Recommendation Report for Planning Permission for Works or Extension to a Dwelling

REF NO: BE/24/26/HH

LOCATION: 31 South Way
Bersted
PO21 5HB

PROPOSAL: Proposed installation of a storage container and additional timber trellis to existing brick boundary wall.

PROPOSED SITE PLAN
Sc. 1:500

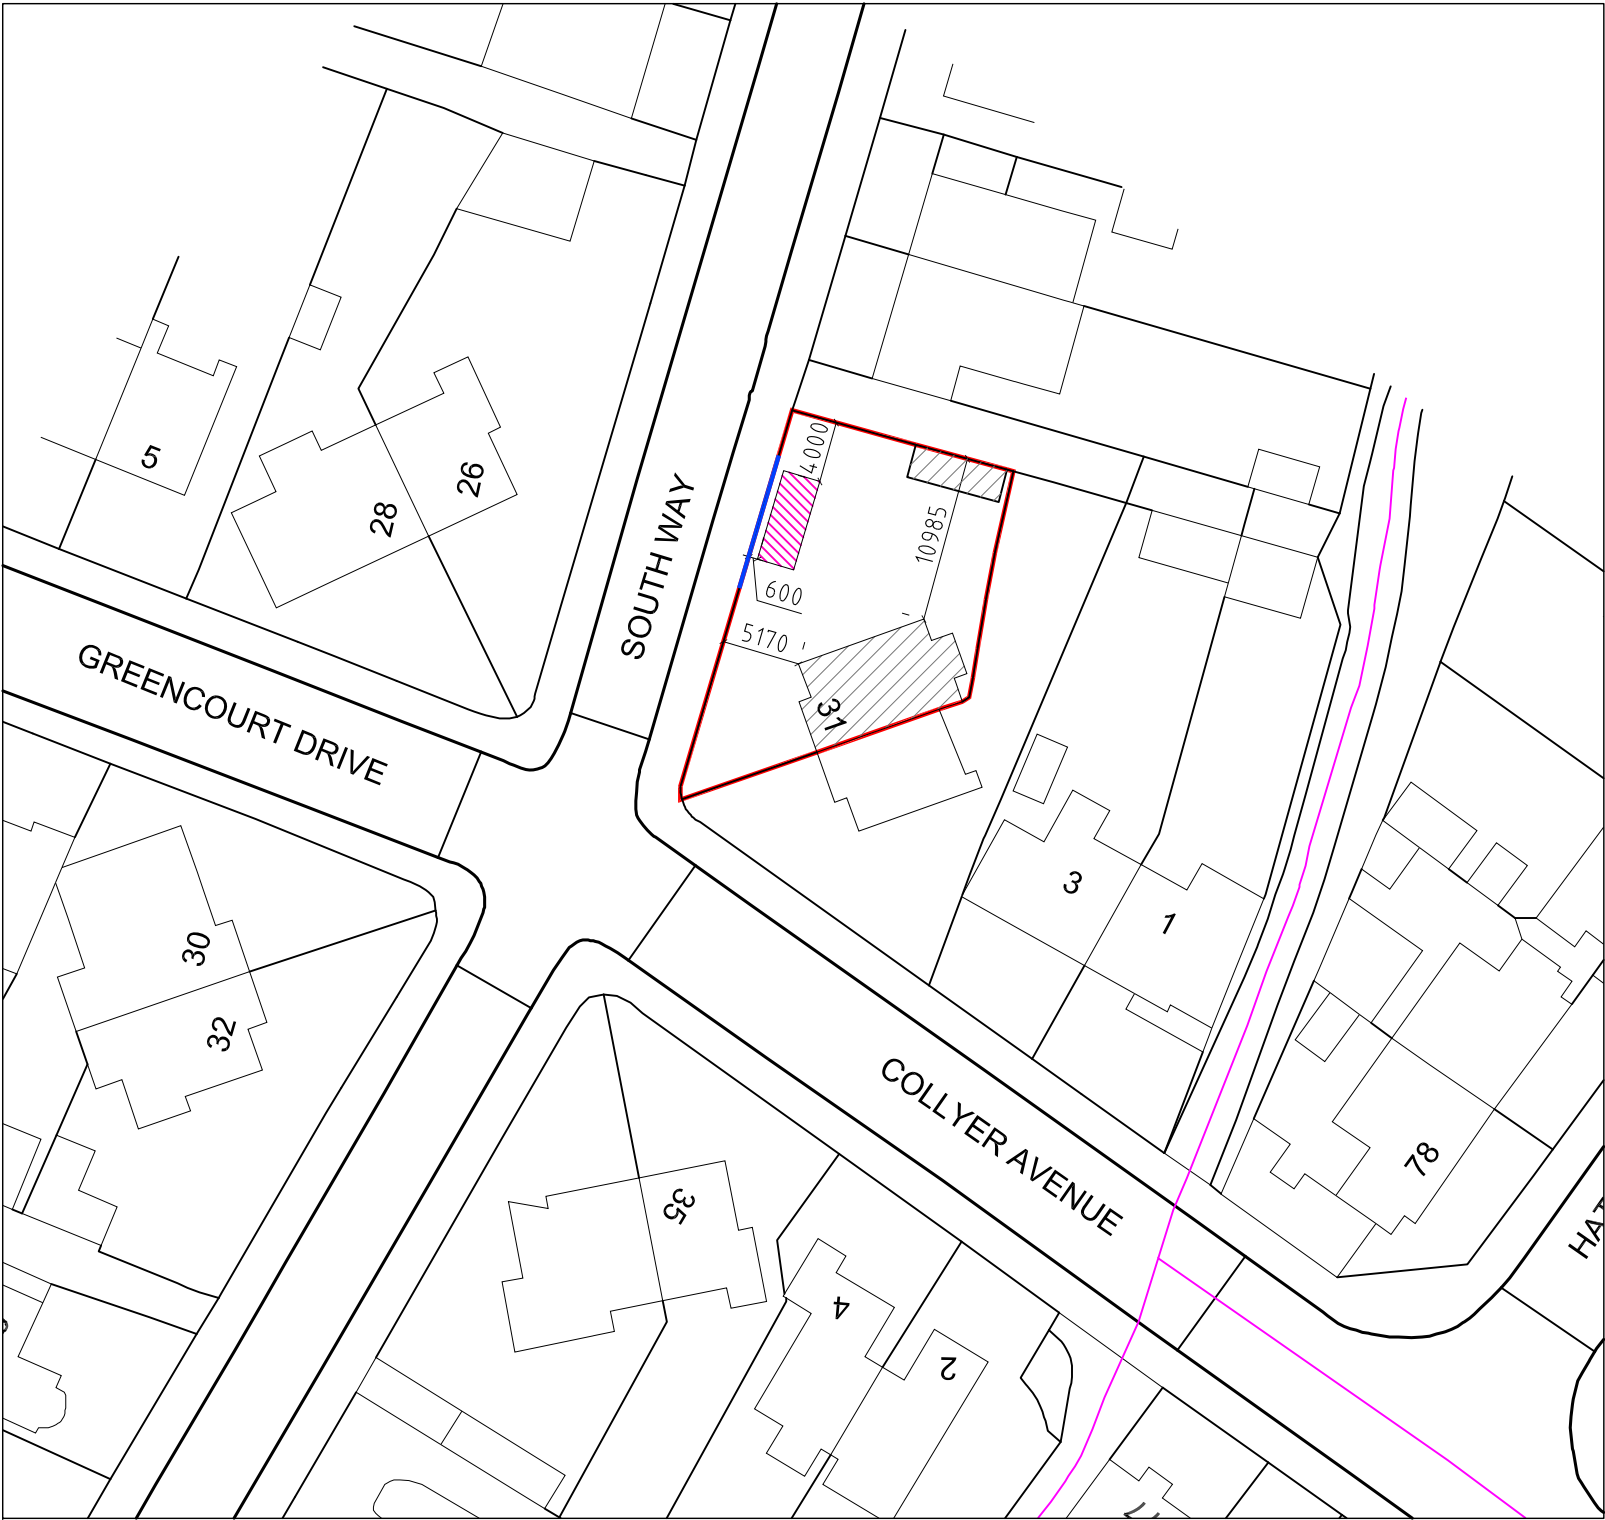
Planning permission is sought to regularise the retention of an existing storage container within the garden, close to the western boundary of the application site, and the installation of a timber trellis along the western boundary to provide visual screening.

The storage container is positioned approximately 0.6m from the western boundary which faces a highway and approximately 4m from the northern boundary, further separated by neighbouring driveway and a garage. Given the site context and the single-storey form of the structure, the development would not give rise to overbearing impacts, loss of light, or unacceptable overshadowing to neighbouring occupiers.

**EXISTING SOUTH WAY STREET VIEW
WEST ELEVATION**
Sc. 1:100@A3

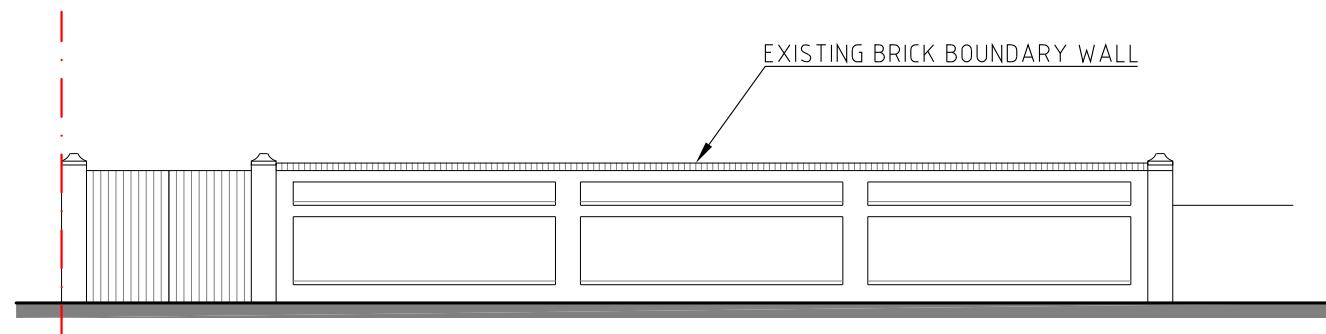
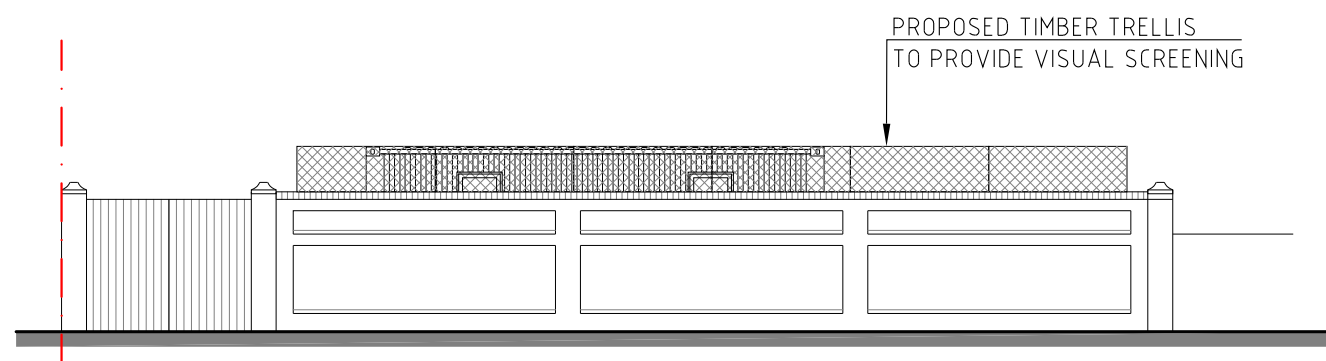
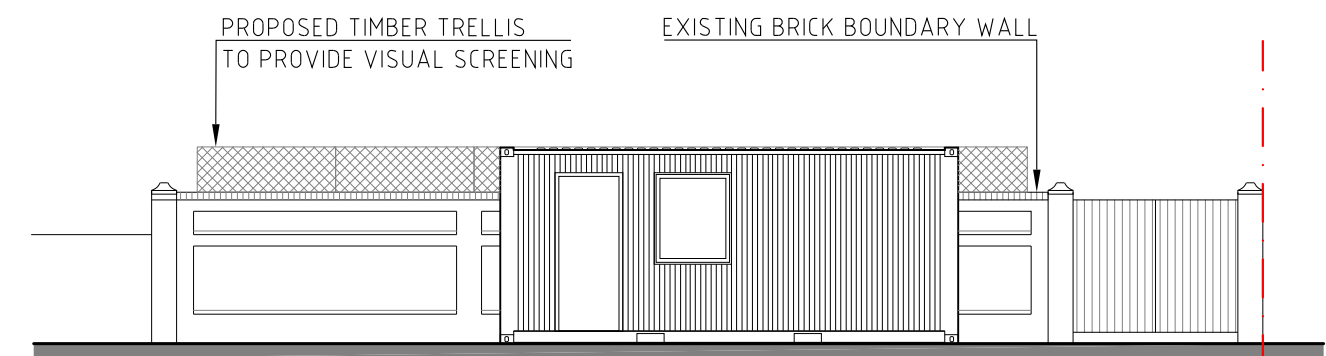
The proposal also includes the installation of a timber trellis above the existing 1.8m high boundary brick wall. The trellis would measure approximately 0.6m in height, resulting in an overall boundary treatment of approximately 2.5m. This would align with the height of the storage container and help to soften its visual impact. Whilst the boundary treatment itself would be higher than the existing arrangement, given that the trellis is not a solid structure and the trellis would not appear dominant or oppressive within the street scene, the proposed trellis is acceptable in this regard. Given the screening provided by the trellis, it is reasonable and necessary to impose a condition requiring the trellis to be installed and retained in perpetuity to ensure that the development continues to provide an acceptable visual amenity over the long term.

The fenestration within the western elevation faces towards the public highway and is largely screened by the existing boundary wall and the proposed trellis. The window within the southern elevation would overlook the private amenity space of the host dwelling with no neighbouring properties to the south. The openings within the eastern elevation are orientated towards the host dwelling's rear garden and are set approximately 12m from the eastern boundary. These separation distances are sufficient to prevent harmful overlooking or loss of privacy to neighbouring occupiers.

- 1 Within one month of the date of this decision, the timber trellis to be installed above the

existing boundary wall shall be erected in full accordance with the approved plans. The trellis shall thereafter be retained in situ, and maintained in a condition that ensures it remains effective in providing visual screening in perpetuity.
